December 8, 2020

**RE: Colorado Springs Utilities – Advanced Technology Campus – Initial Review Comments**  
**File: CPC A 20-00143, CPC ZC 20-00159, CPC MP 20-00160**

MASTER PLAN  
SHEET 1 OF 1

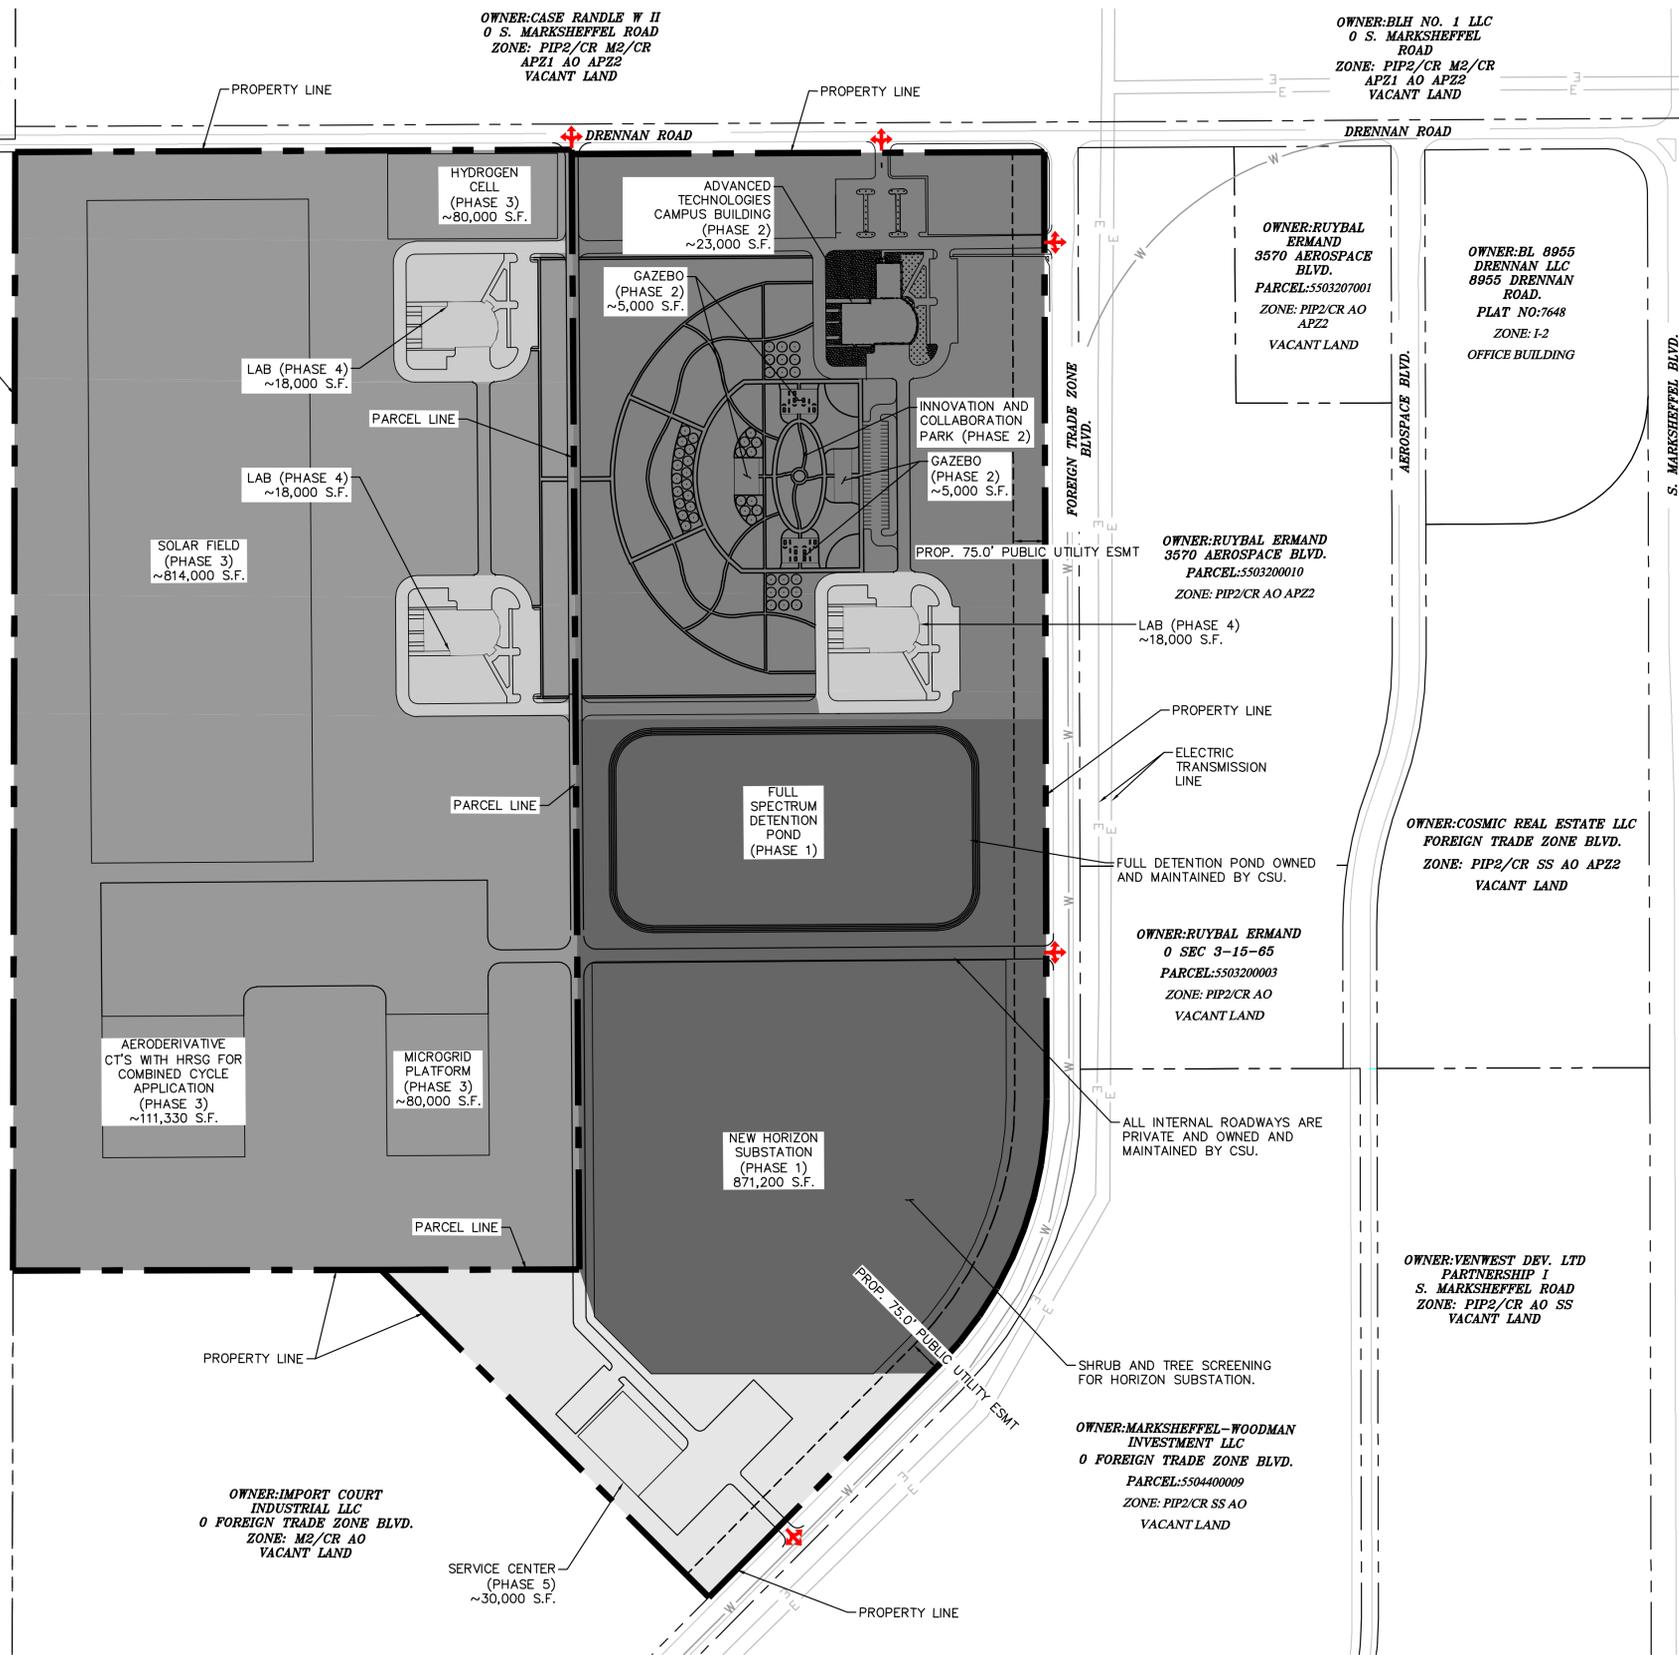
3. Site Data/Land Use – add or correct the following to the site data on sheet one of the plan:
  - a. Update the legal description per surveyor comments

- b. Add existing zone district: El Paso County I-2/A-5/CAD-O
  - c. Add proposed zone district: City of Colorado Springs PF/AO (Public Facility with Airport Overlay)

- a. Add a notes section to reflect all notes as identified below from City Engineering and Traffic
  - b. Add a note that all internal roadways will be private and owned and maintained by CSU. (Can you also clarify if this property will have secured access? This may change comments from CSFD.)

- c. Add notes to clarify the intent of the property to be screened/ buffered
  - d. Staff wants to clarify if there would be any significant noise created from any portions of the facilities operating on site, if so add a note so it is clear to future surrounding development the potential noise impacts

5. Add access arrows to show future access points from Drennan Road, Foreign Trade Zone Blvd, and future internal roadways.
6. Please remove floorplan data from plan.
  - a. If preferred more detailed line work can be removed across the depictions. Most important are access, use and a general understanding of building/layout.
7. Include zone districts and land uses on adjacent properties
8. The Geological Hazard Waiver was completed and has been accepted by the City. Please see the enclosed copy of the signed waiver.
9. For staff's better understanding and moving forward to public hearing can you please share further details for each project phase as listed on the plan. You can update that information here in the response letter and if see fit elaborate on the plan notes.

1. Label Full Spectrum Detention Pond as being maintained by Colorado Springs Utilities.
2. If Foreign Trade Zone Blvd is being modified with this development, drainage infrastructure along roadway must be analyzed and potentially improved.

1. The developer shall dedicate approximately 11 feet of ROW along the north side of lot (TSN#5504100001) on Drennan Road. This dedication must be consistent with the eastern property (TSN#5504101001) line ROW. Show/label this on the master plan.
